# CITY OF ALBUQUERQUE

June 18, 2020

**RE: Lot 12 Block 6 Volcano Cliffs Unit 18 SAD 228  
6528 Kimmick Dr. NW  
Grading and Drainage Plan  
Engineers Stamp Date 5/12/2020 (D10D003M12)**

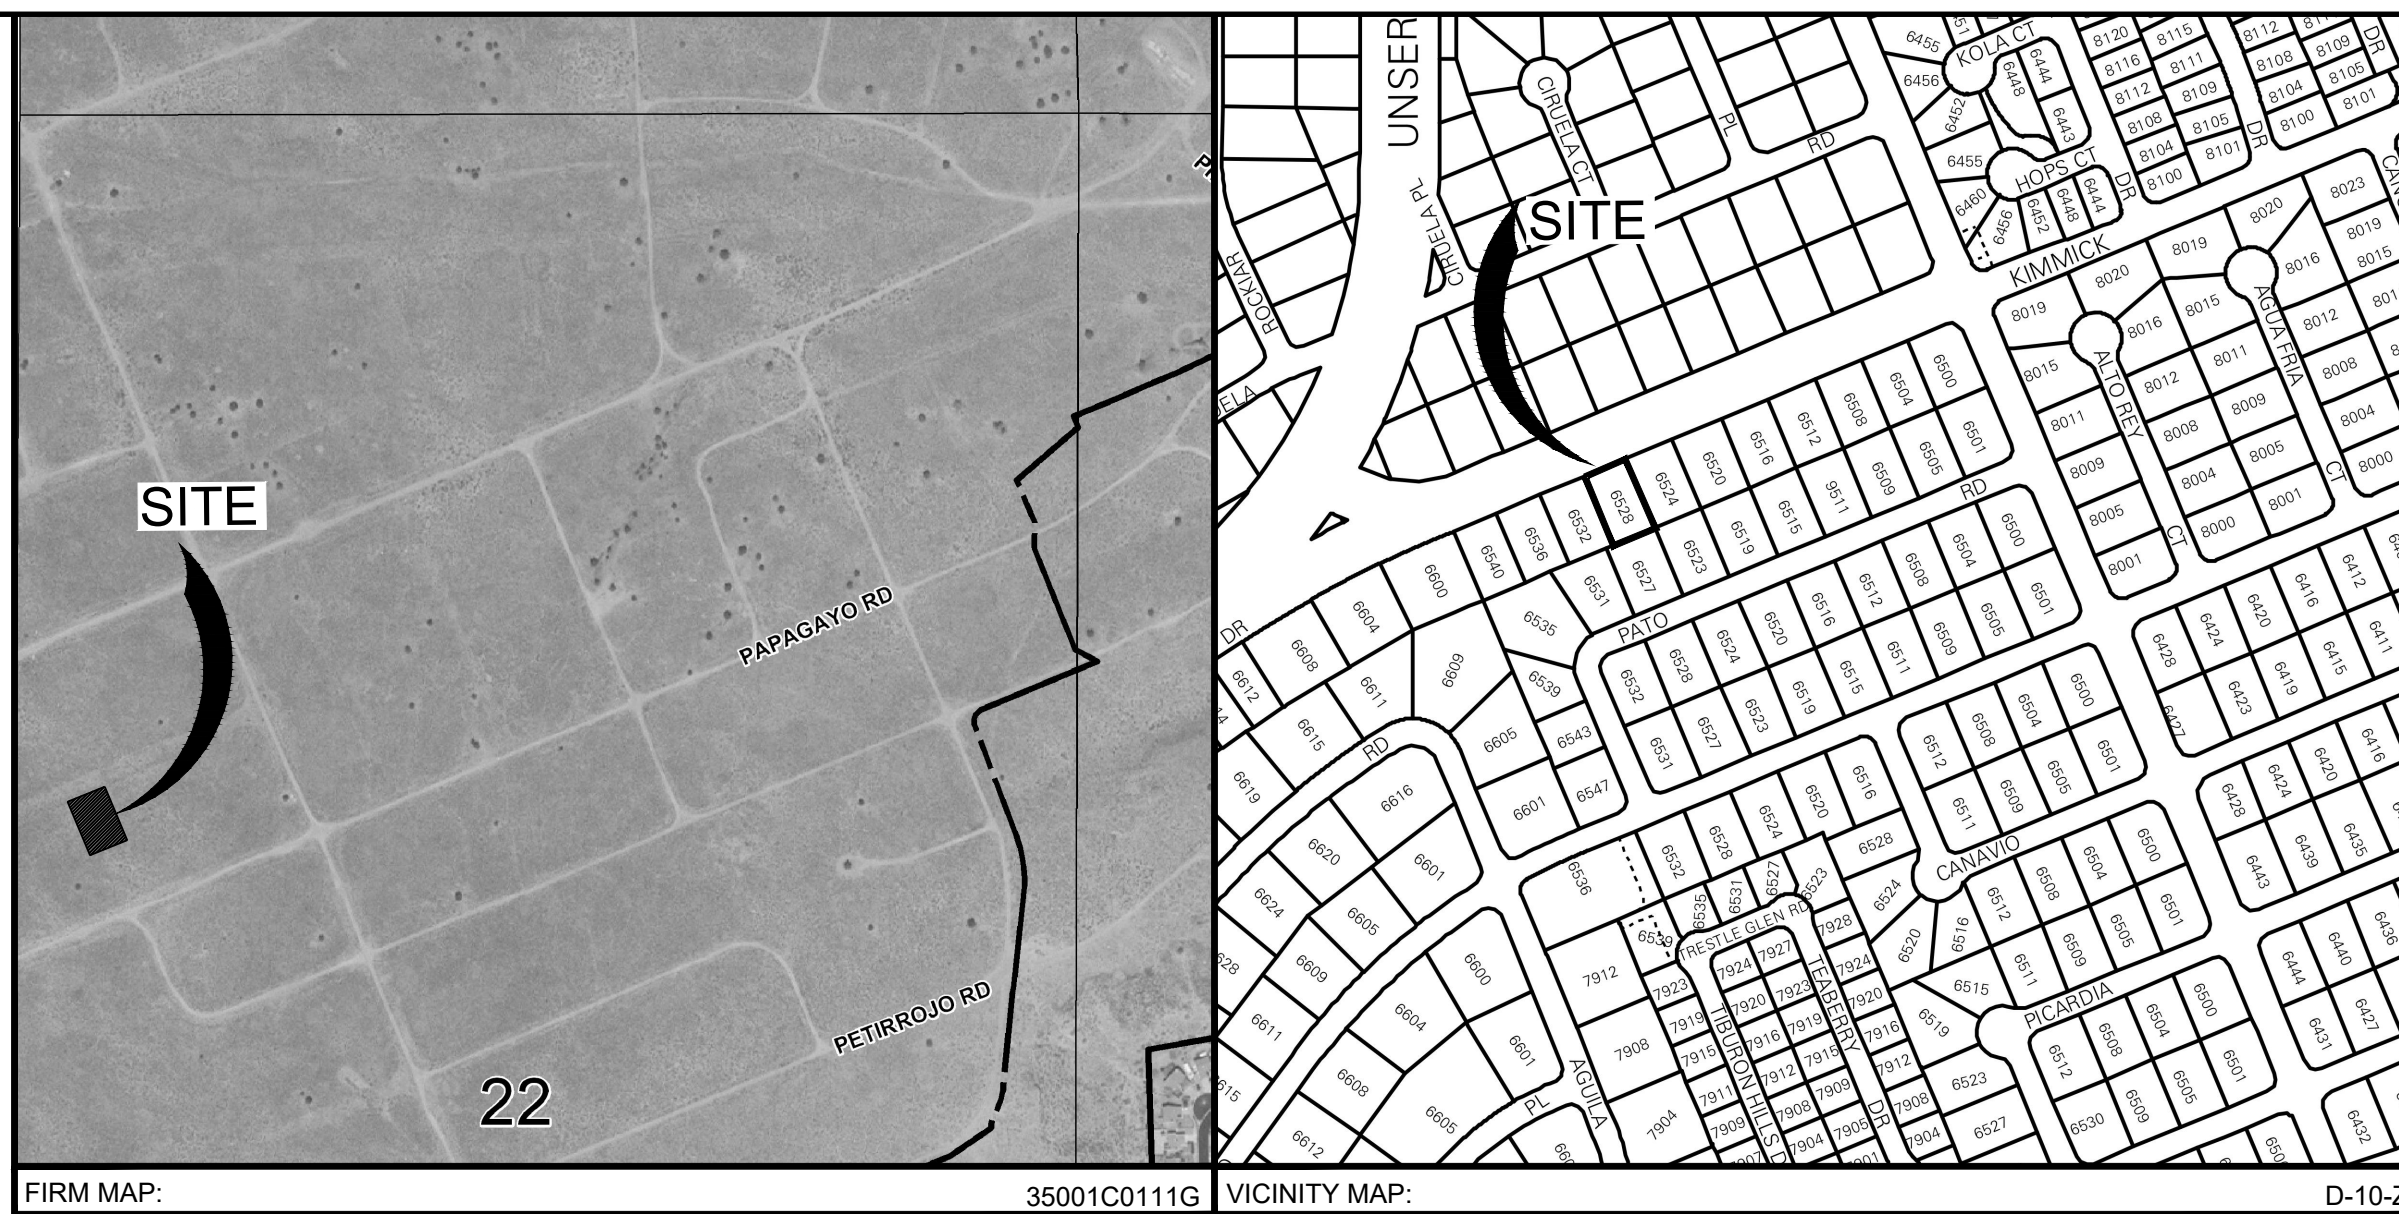
- Provide clarification for note 1
- Provide a description for Darkened line.
